**KIRKLEES METROPOLITAN COUNCIL
INVESTMENT & REGENERATION SERVICE**

Reference No:	2024/70/91236/W
Site Address:	Land at, Lingards Road, Slaithwaite, Huddersfield, HD7 5HY
Description:	Variation of condition 2 (plans) of previous permission 2020/93954 for erection of 42 dwellings and associated works
Recommending Officer:	Katie Chew

DECISION – Section 73 Variation of Condition – Approve

Officer Report

PLOT 23.

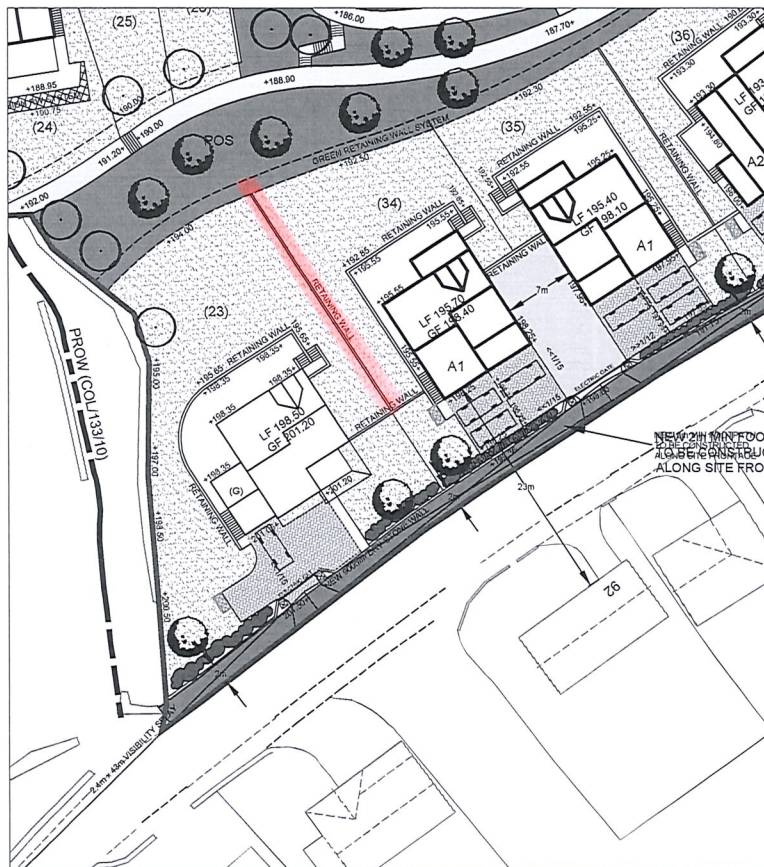
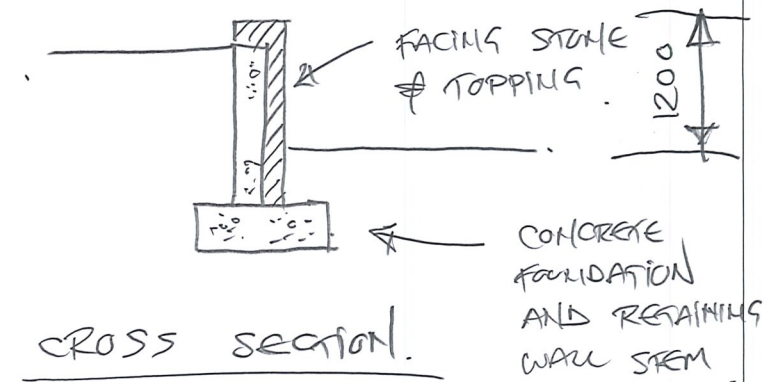
Plot 23:

- Relocation of garage from internal ground floor to the side of the dwelling;
- Provision of a glass fronted single storey structure to be used as an entrance into the property;
- Addition of a dining room at lower ground floor level (beneath the garage);
- Provision of an electric gate;
- Removal of the originally approved single storey sunroom and terrace to the rear;
- Removal of originally approved side projection. Alterations are also proposed to the rear patio area and stairways, which sees the patio area increase slightly in size and curve around the dwelling to the west.
- The as approved plan for plot 23, from 2020/93954, is referenced 2019/572/101 rev. D
- The proposed plan, as part of this S73, for plot 23 is referenced 2019/572/SK13 Rev. K.

- The kitchen and snug at Plot 23 would be under the proposed garage, but there would be no basement underneath the kitchen and snug. If the basement justification given is correct, why has no basement been provided here?
- Concerns regarding the inclusion of a basement to some of the plots and the reasons for it.
- Construction concerns for the basement.

Officer note: Noted. The proposals have however, now been amended to remove the basement from Plot 23.

Rev B Plots 23 & 34/35 updated to suit clients instruction. 24.09.24 HH  
Basement levels removed.

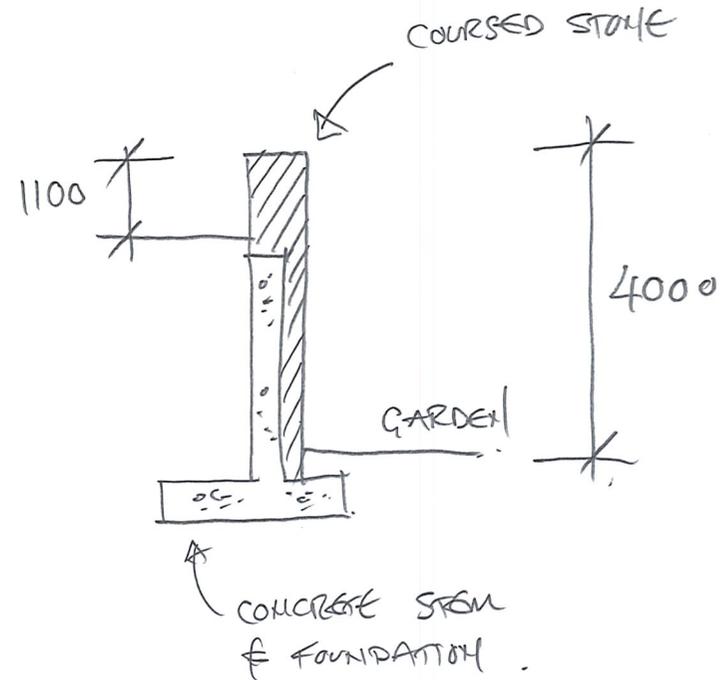
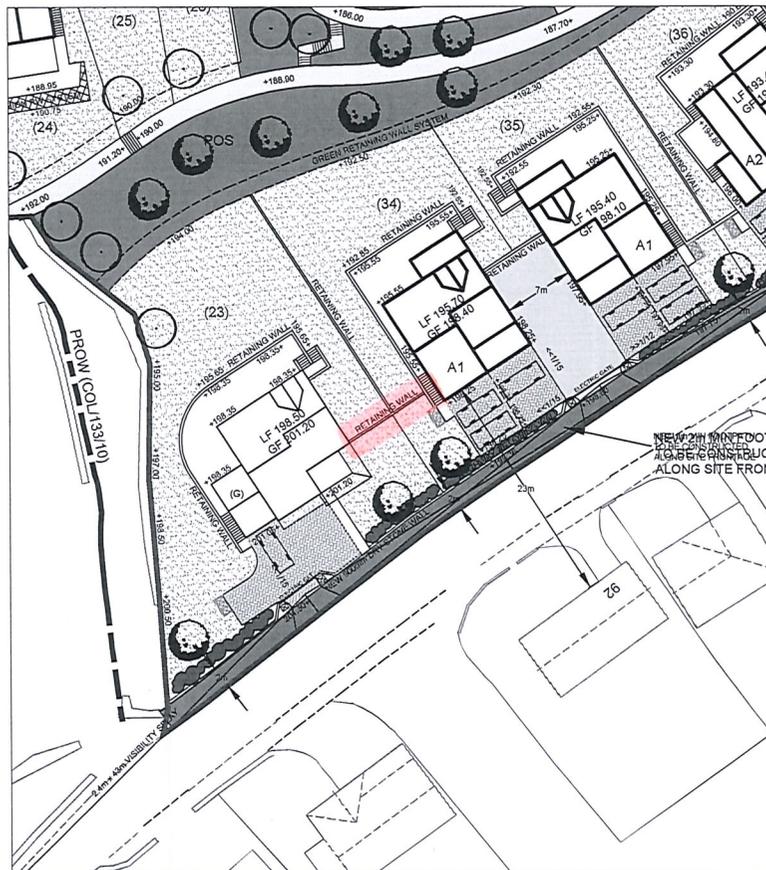
Following receipt of KC Highways comments, amendments were made to plots 34 & 35 to extend the length of the driveways to at least 6 metres to allow space for two

KC Highways Development Management: No objections subject to the length of the driveway to the front of the proposed car ports of Plots 34 & 35 being extended to 6 metres to allow space for 2 cars to park in tandem.

cars to park in tandem. Alterations were also made to remove the originally proposed (as part of this S73 submission) car ports and basements of these dwellings. Furthermore, alterations were made to revise the plans originally submitted for Plot 23 (again, as part of this application); this included to removal of the proposed basement and reduce the double garage down to a single garage.

Officer note: Amended plans have been received in accordance with the above request.
